Recommendation Report for Planning Permission for Works or Extension to a Dwelling

REF NO: M/64/21/HH

LOCATION: 132A Elmer Road
Bognor Regis
PO22 6HZ

PROPOSAL: Installation of a timber structure in rear

new garage

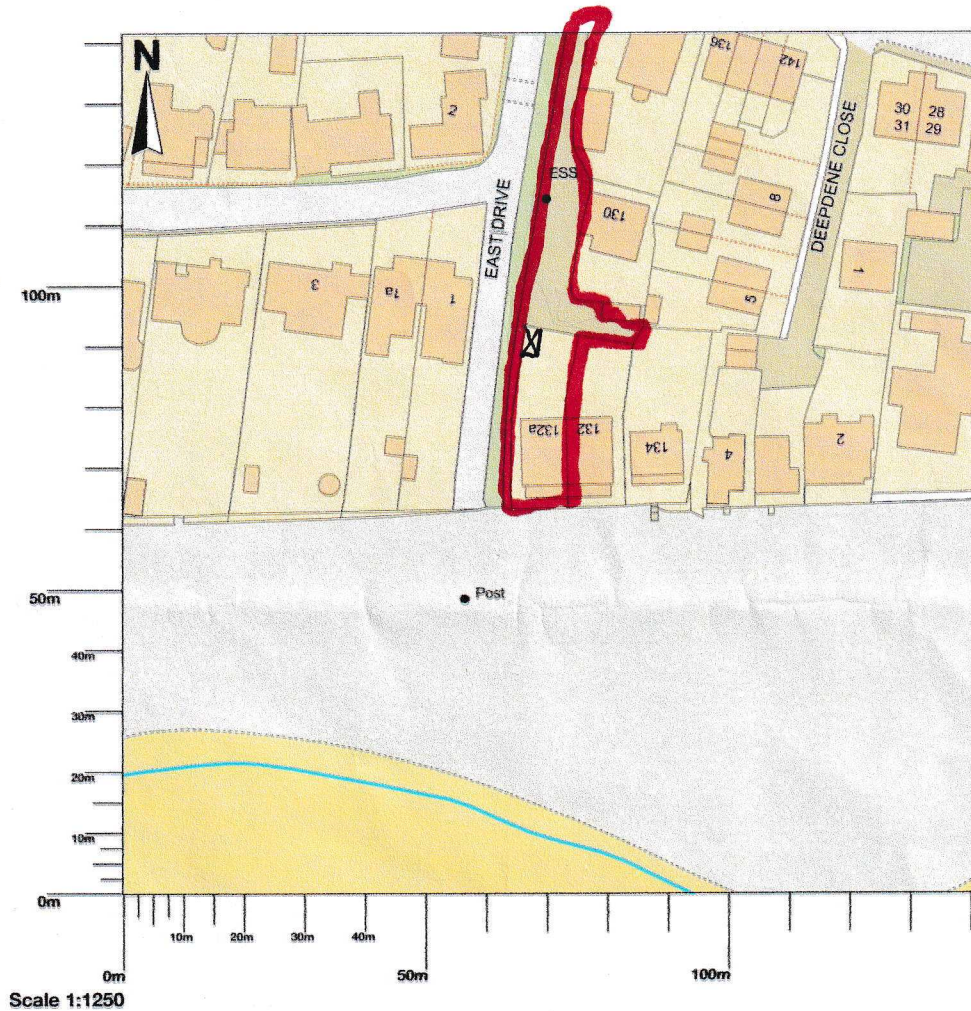
The garage will be to the front of the property to the existing parking area, there will still be ample parking on site even with the loss of 1 parking space to accommodate the structure.

The size of the structure is appropriate for its intended use and will be built in materials already found on site. Apart from its positioning on site, the structure could be built under permitted development allowances. The garage will be located at the end of a long private drive which serves a small number of dwellings and will therefore not have any impact on the street scene.

The garage is to be located away from other dwellings which are served by the private drive and be located adjacent to East Drive. It is located to the front of the host dwelling and therefore the 45-degree rule is not applicable in this instance. Its size, scale and location are such that it will not be overbearing to any neighbouring properties.
